June 7, 2019

**Re: Horizon 3**  
**8830 horizon Blvd NE Albuquerque NM**  
**Traffic Circulation Layout**  
Engineer's/Architect's Stamp **05-28-2019** (C17D127)

Based upon the information provided in your submittal received 06-05-19, the above referenced plan cannot be approved for Building Permit until the following comments are addressed:

Traffic Circulation Layout  
TCL001

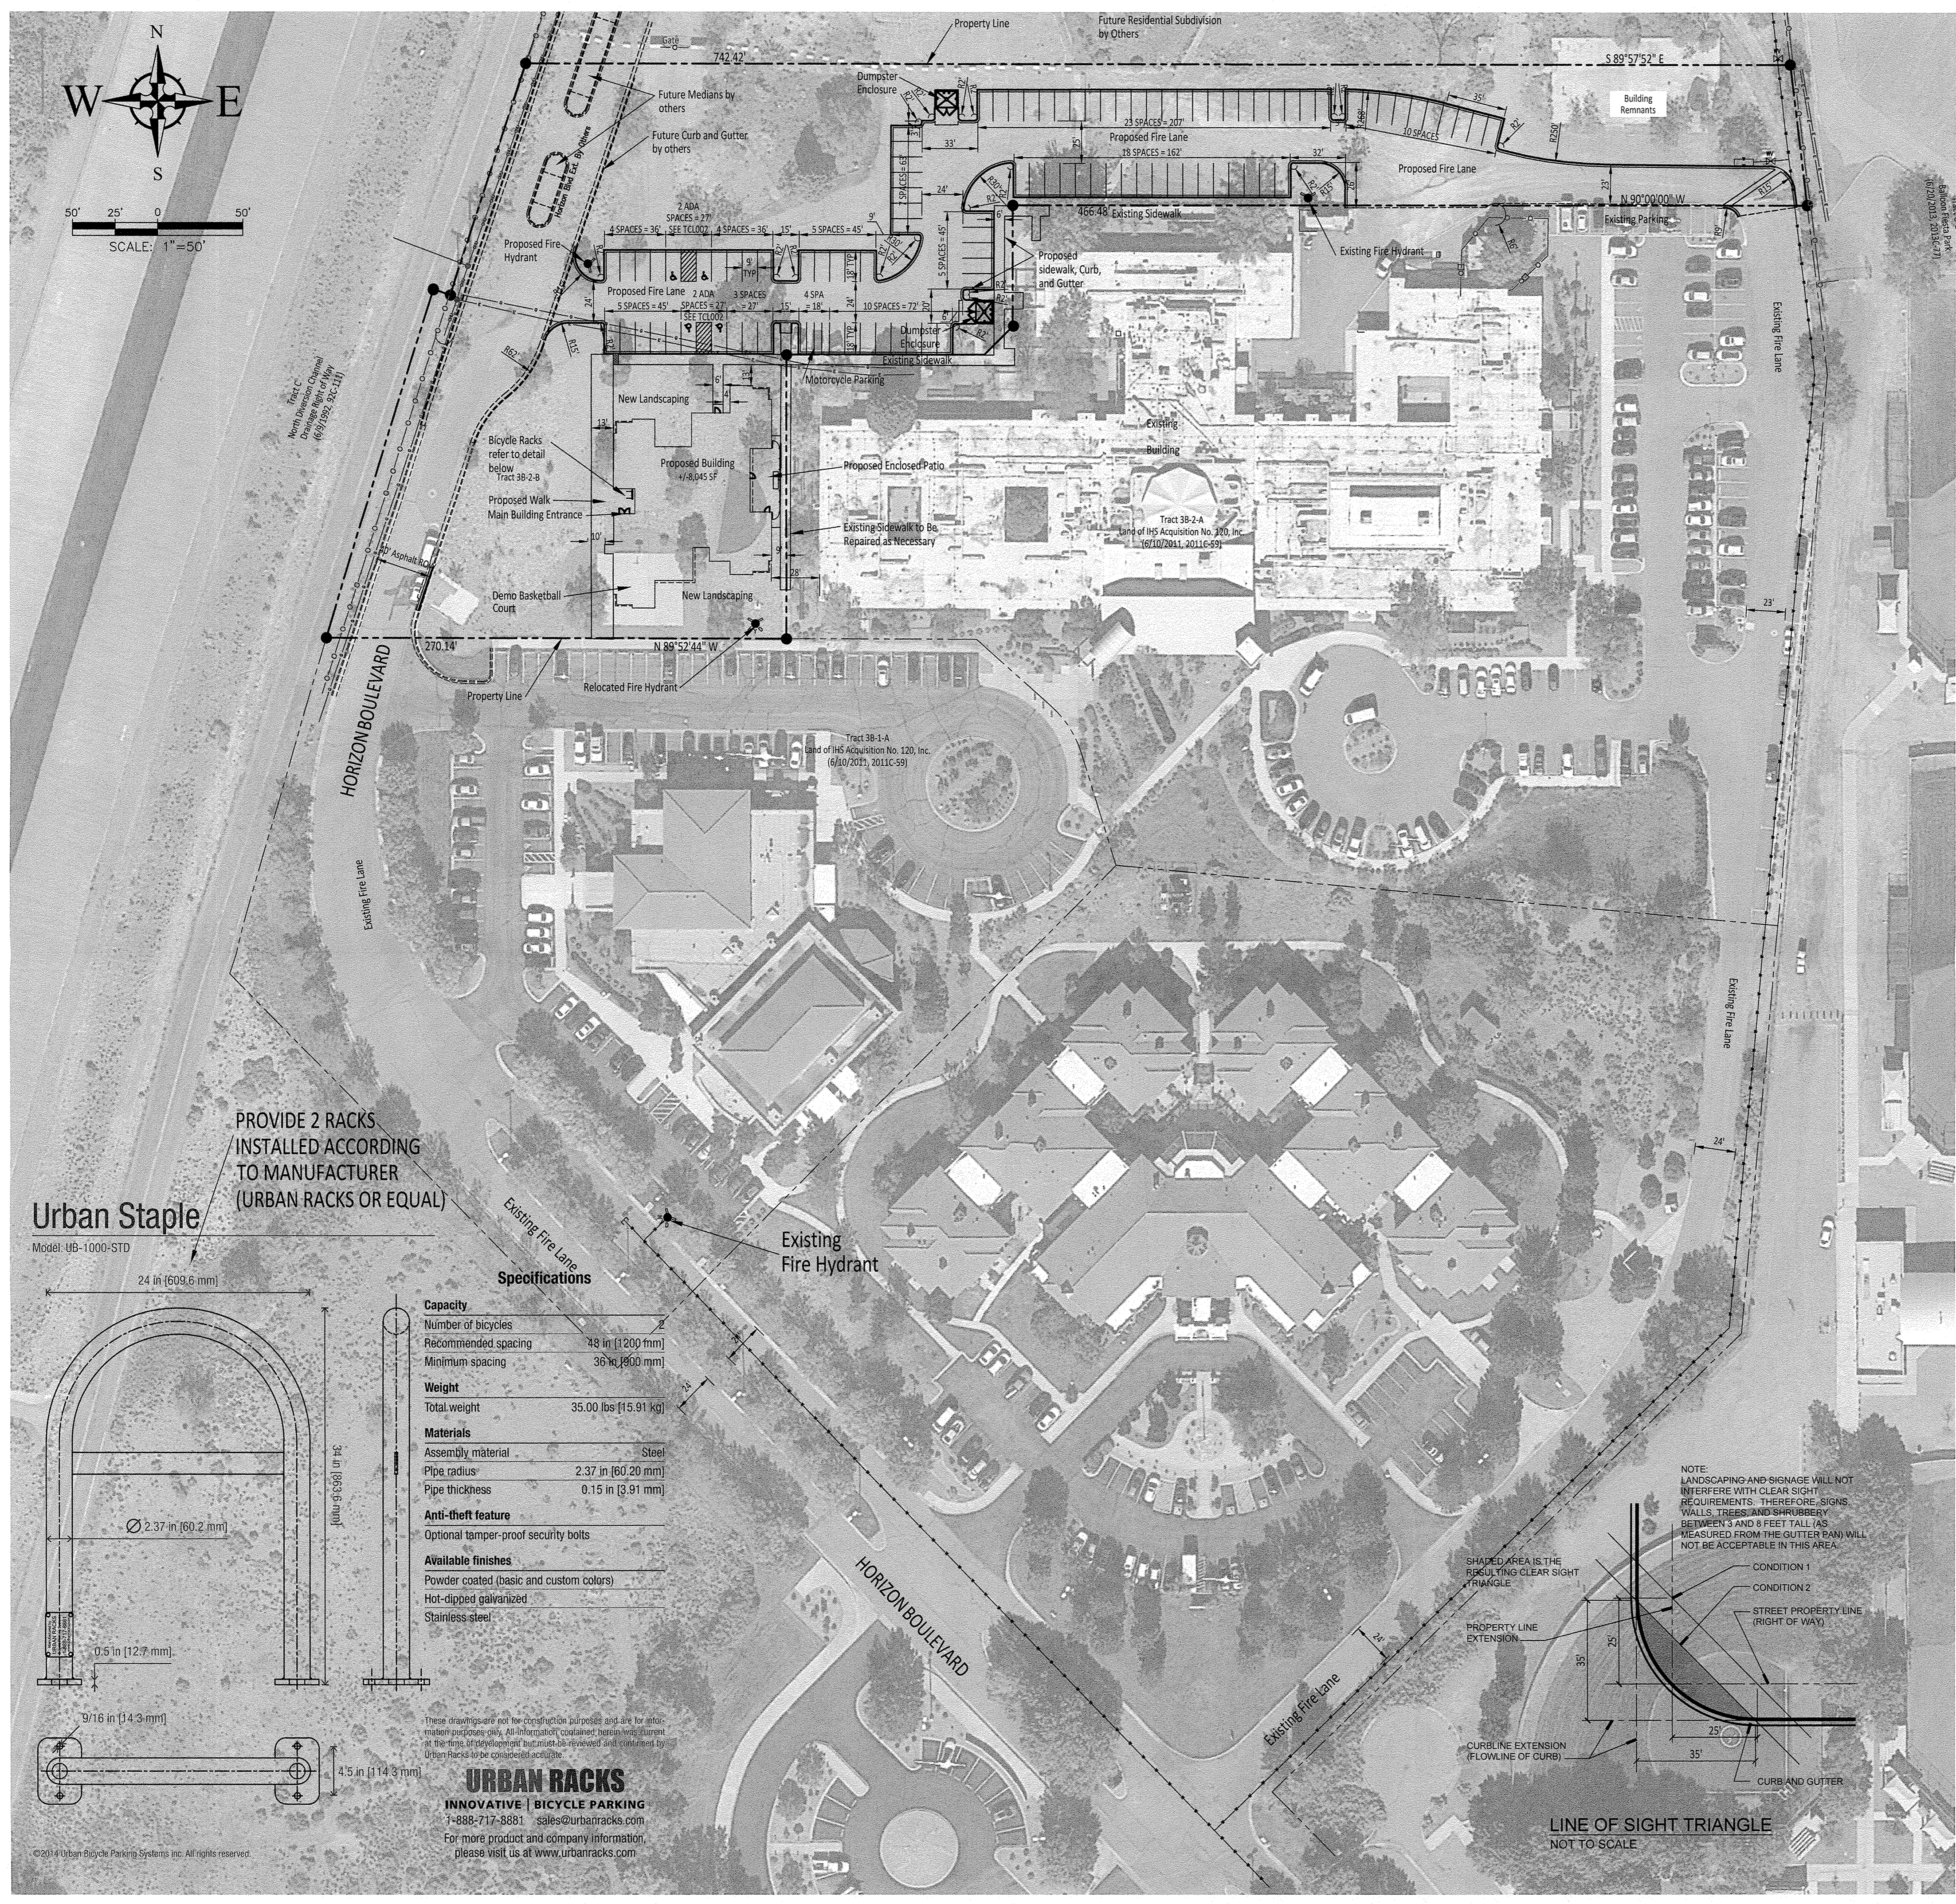
1. Show the clear sight triangle and add the following note to the plan:  
"Landscaping and signage will not interfere with clear sight requirements.  
Therefore, signs, walls, trees, and shrubbery between 3 and 8 feet tall (as measured from the gutter pan) will not be acceptable in the clear sight triangle."
2. change the design of the entrance driveway to perpendicular with a maximum of ten degree skew.

3. Consider removing one of the medians. The access road must transition after the site access intersection.

4. Please clarify if these features are being removed.
